CITY OF ALBUQUERQUE

June 21, 2022

**Re: Blake's Lotaburger #27 Drive-Thru
2301 Carlisle Blvd NE
Traffic Circulation Layout
Architect's Stamp NONE (H16-D106)**

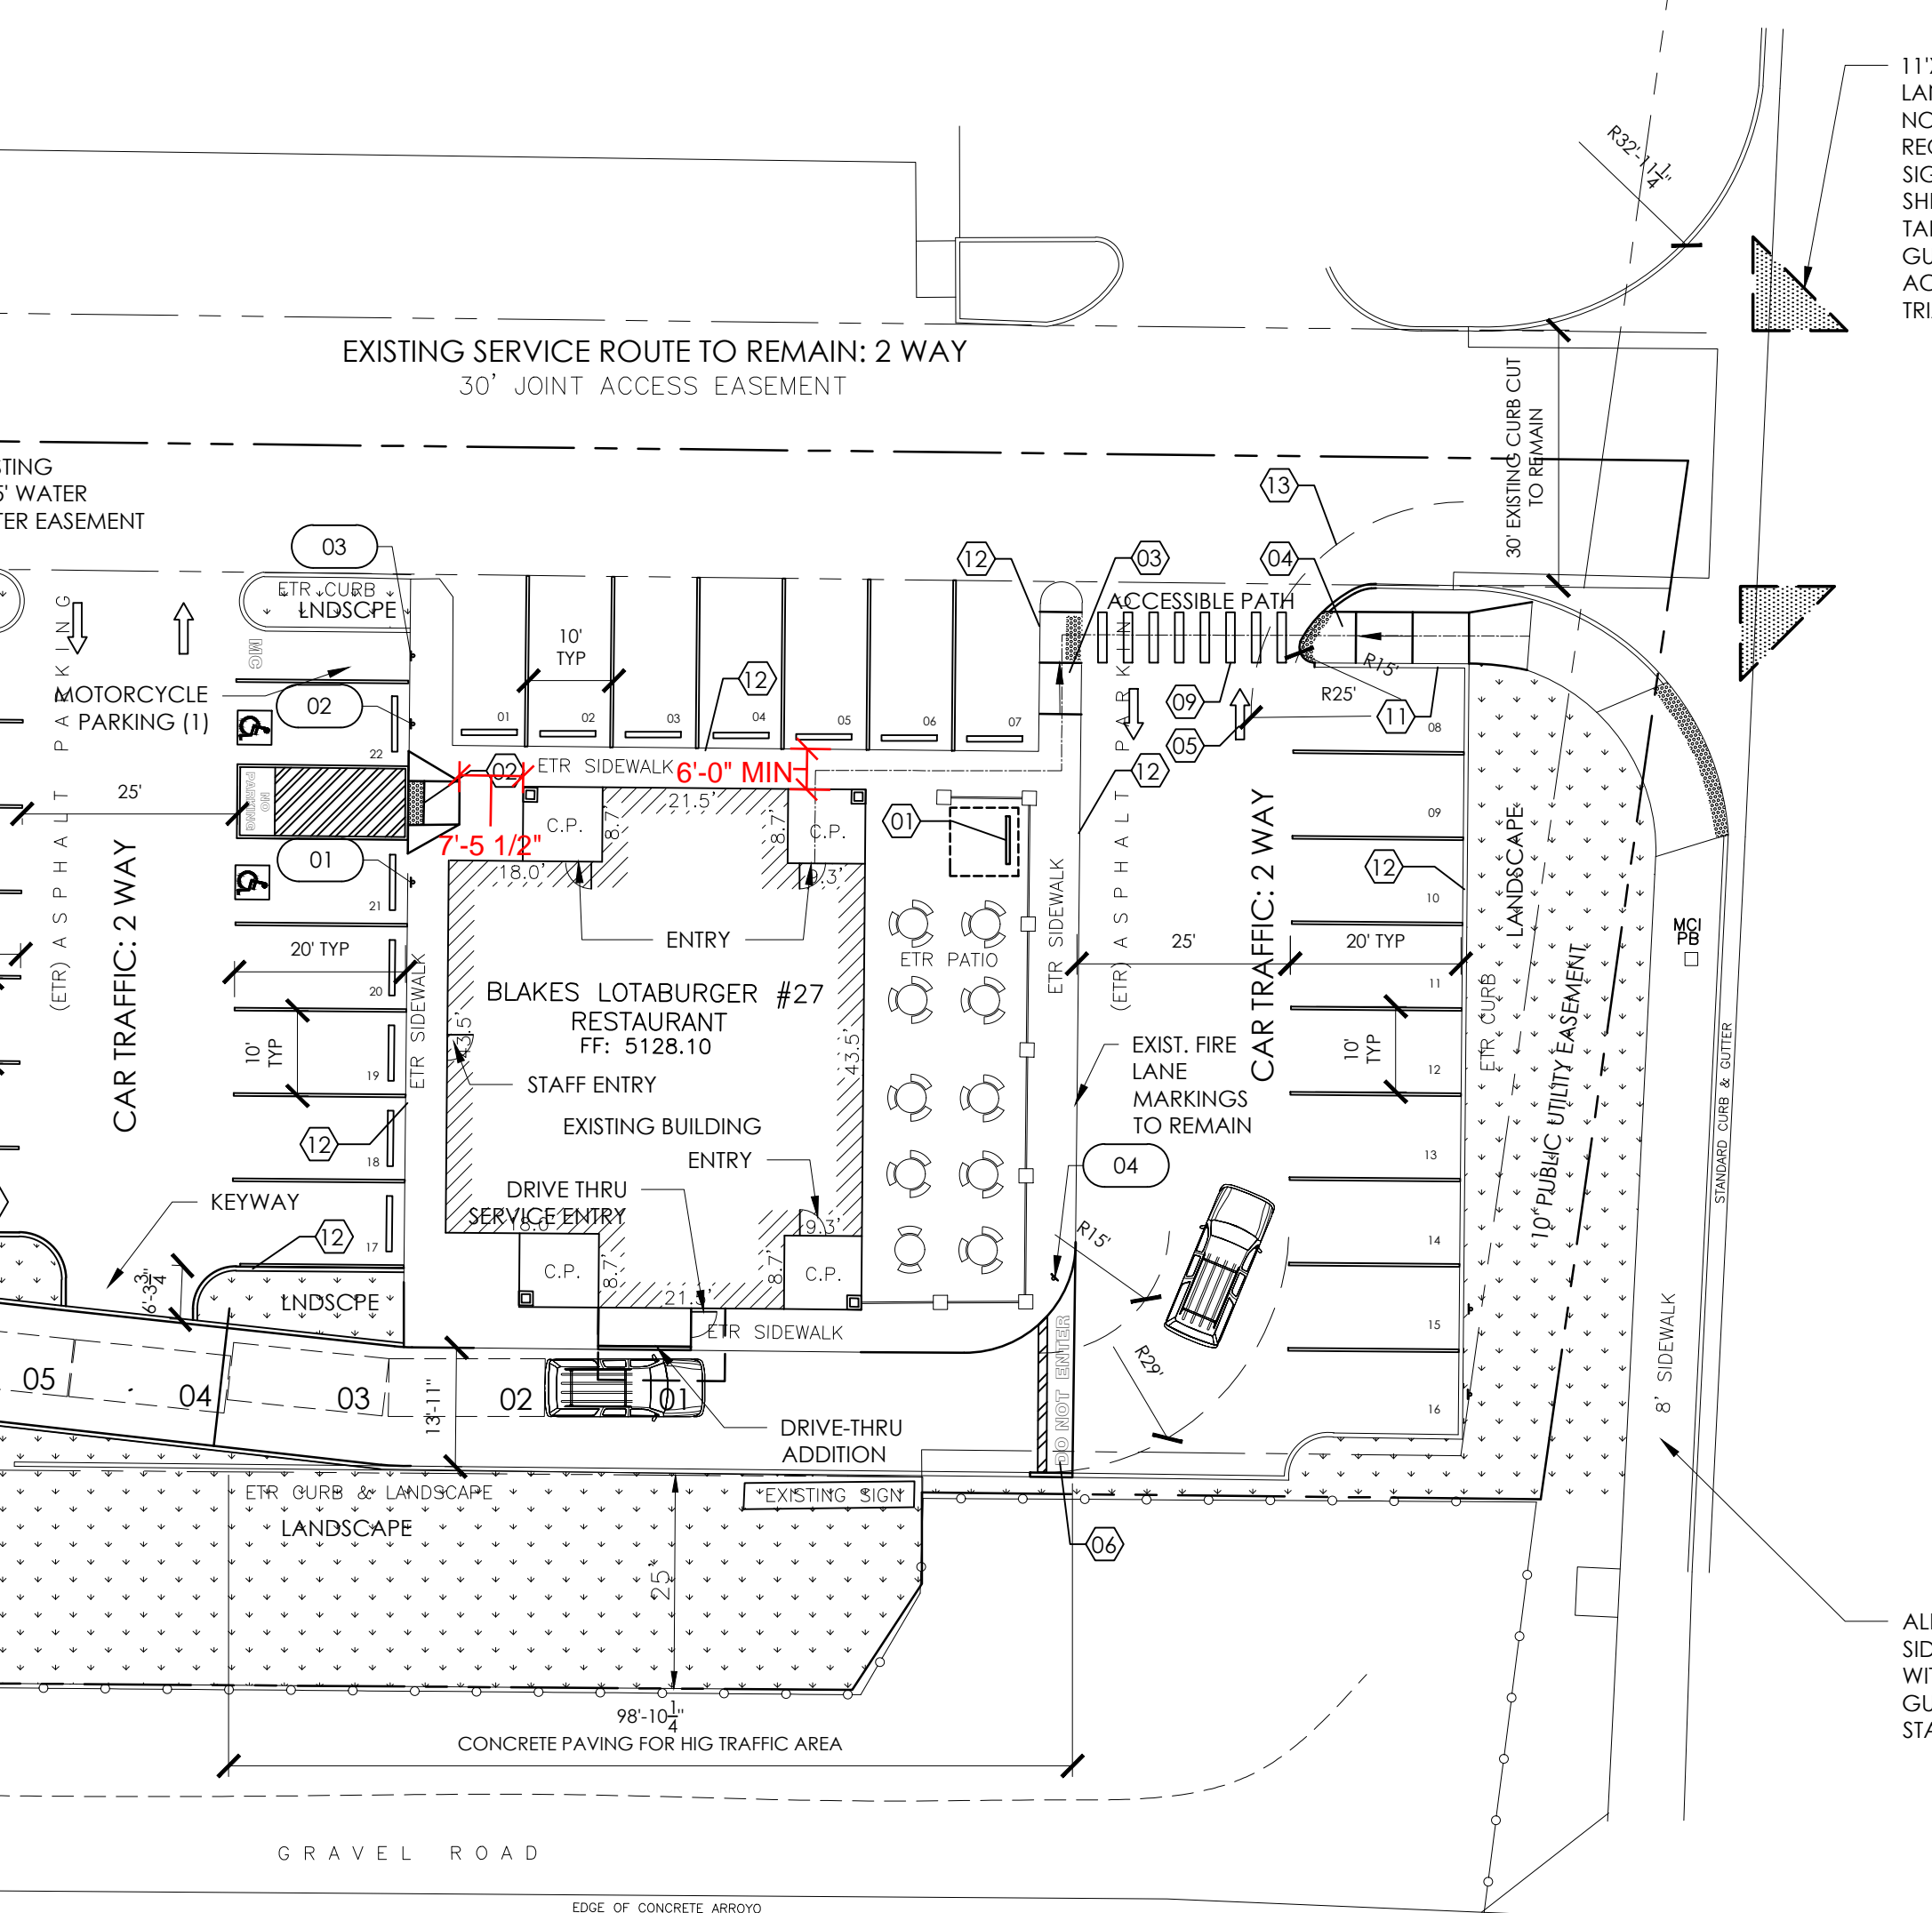
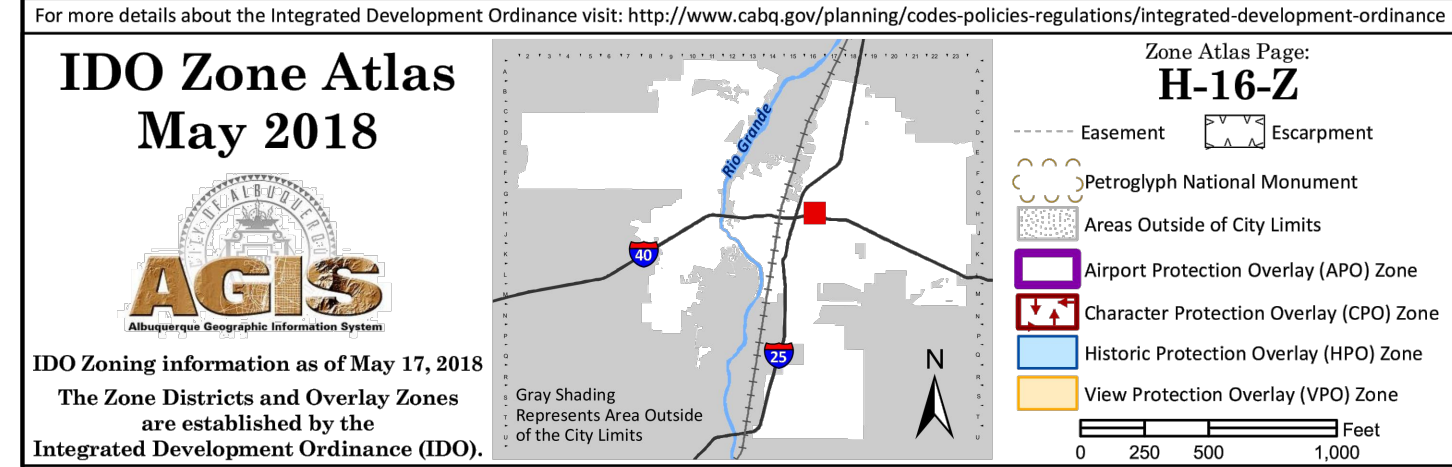
6. **The proposed Drive-thru bypass:**
 - The bypass will only complicate the traffic flow during peak hours. Please provide an explanation for this proposal.

24. ADA accessible pedestrian pathway should not be placed behind parking space or adjacent to a vehicular way. Vehicle and pedestrian/wheel chair conflicts should be avoided as much as possible. **This situation occurs adjacent to the western portion of Crosswalk Markings/stripping. Provide curbing and 6 ft pedestrian pathway.**

30. **Crosswalk Markings:**
 - Provide details.
 - Status of ADA curb ramp on the west side of crosswalk markings.
31. Please provide a Intersection sight distance exhibit for the access easement and Carlisle.

AS-104

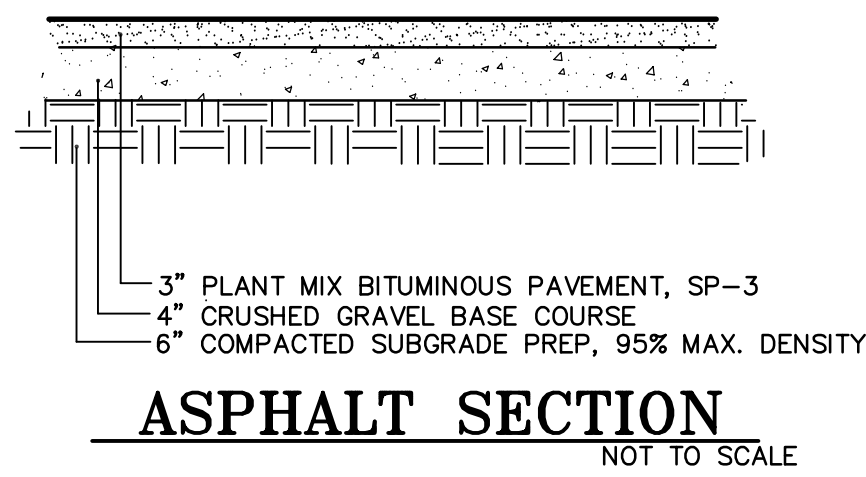
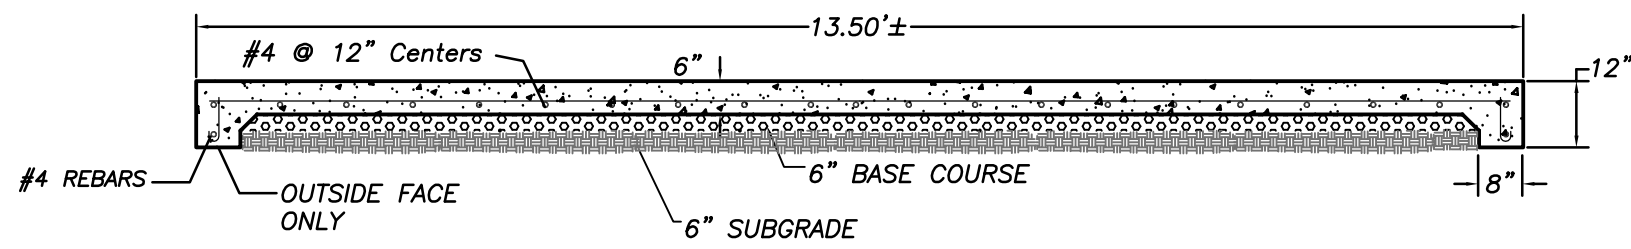
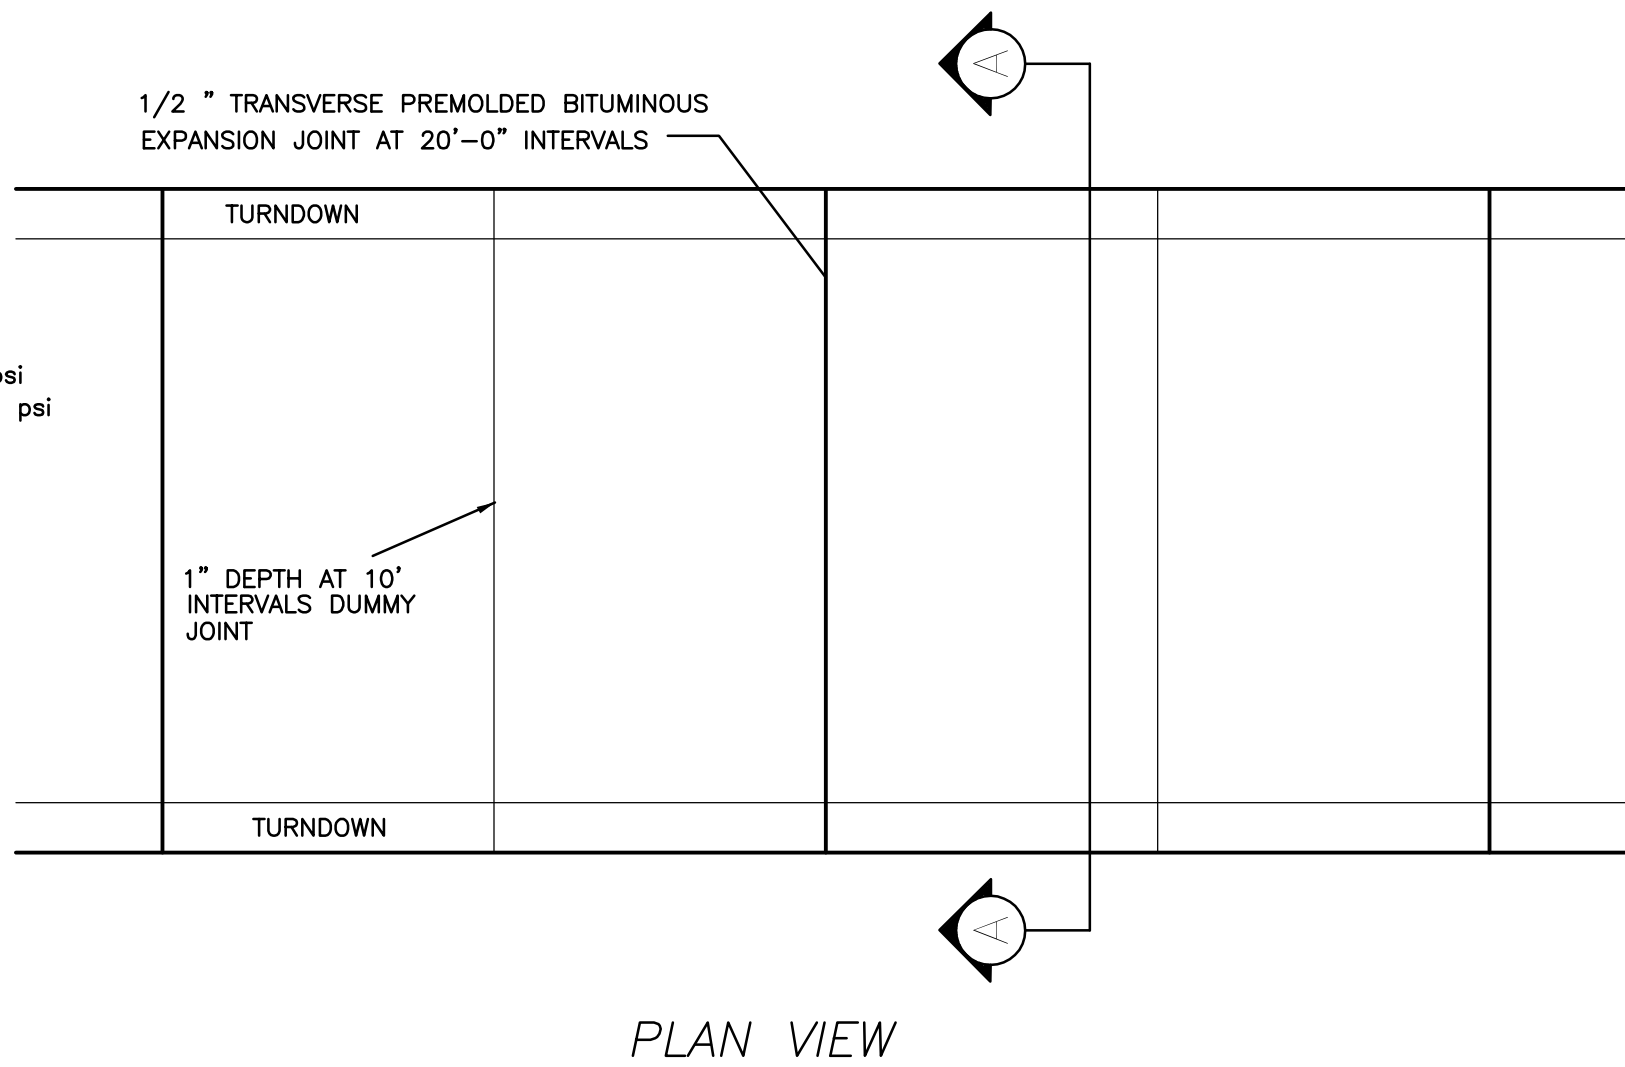
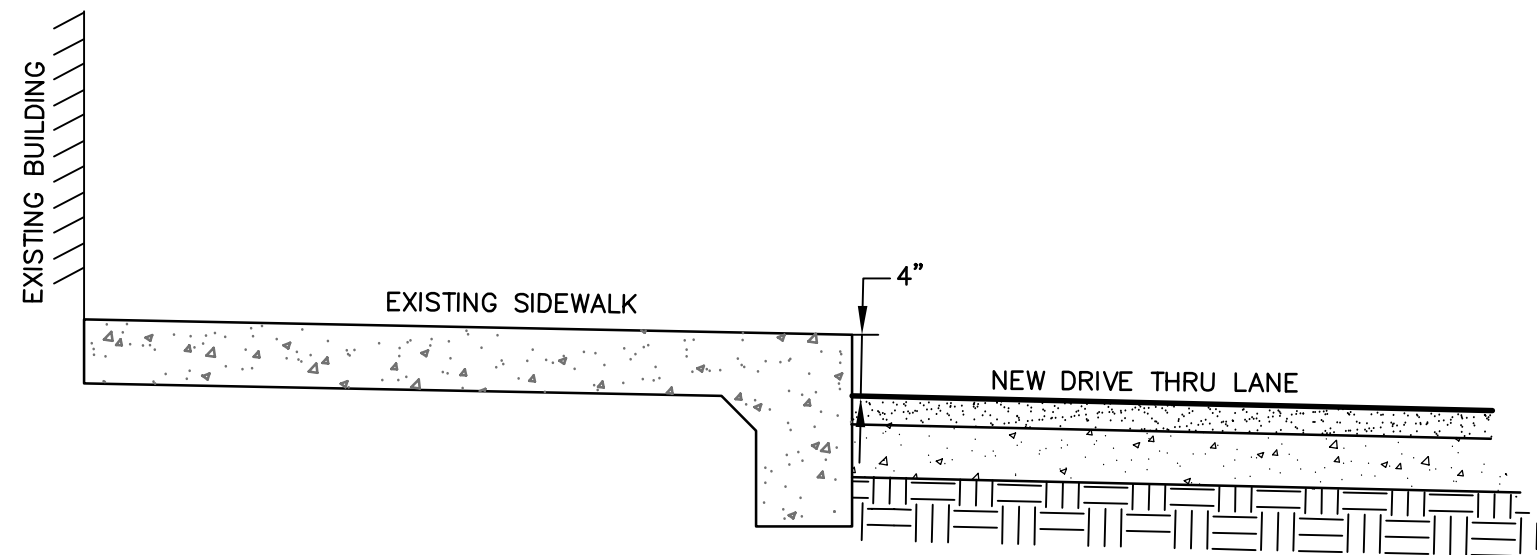
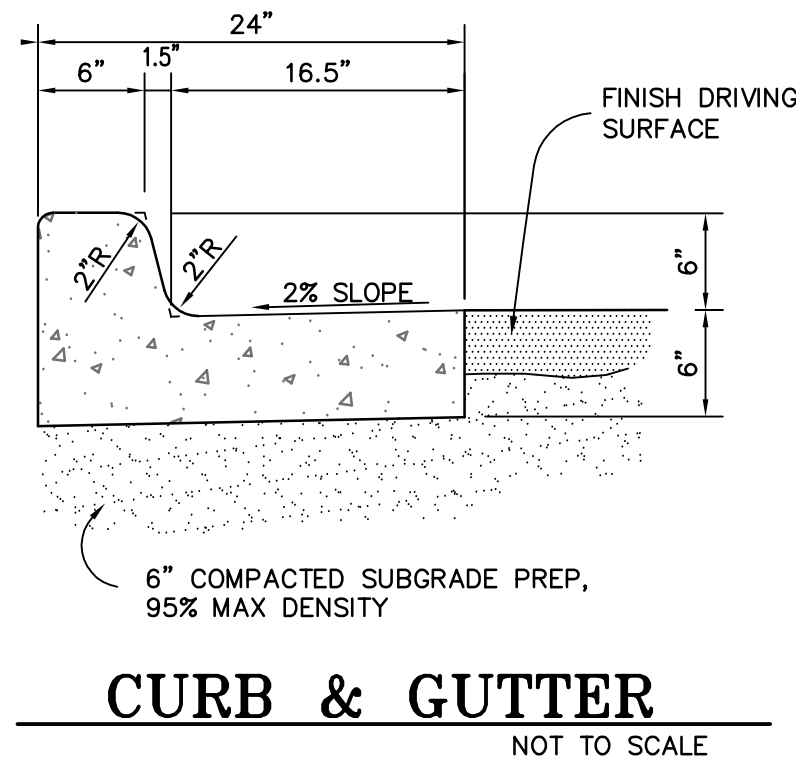
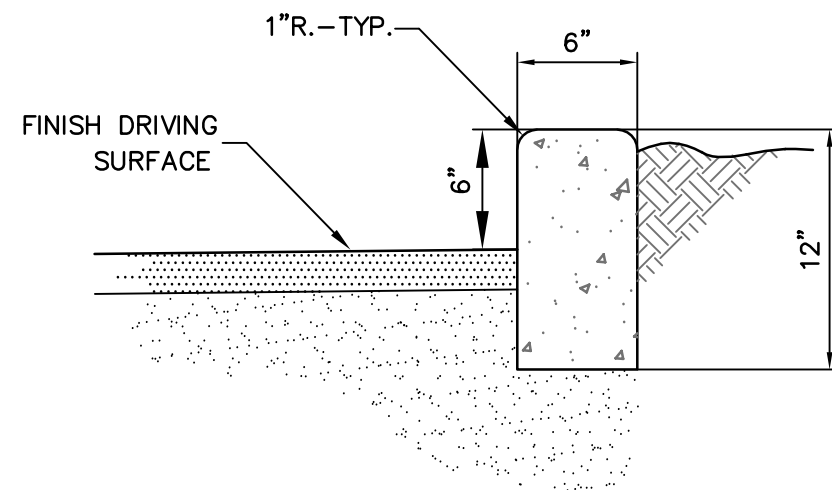
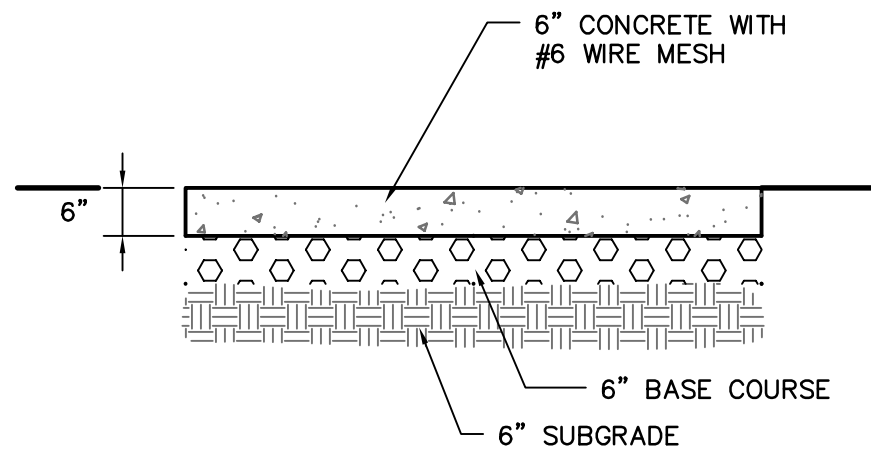
3. The traffic circulation layout must be stamped, signed, and dated by an engineer or architect licensed in the state of New Mexico. **Sheets AS-103 and AS-104 stamp will need to be provided.**

7. **ADA curb ramp:** A reference note will need to be provided for the proposed detail C4 on sheet As-104.
8. All proposed infrastructure within Sheet AS-104 will need reference notes for proposed details on sheet AS-103, and C2.
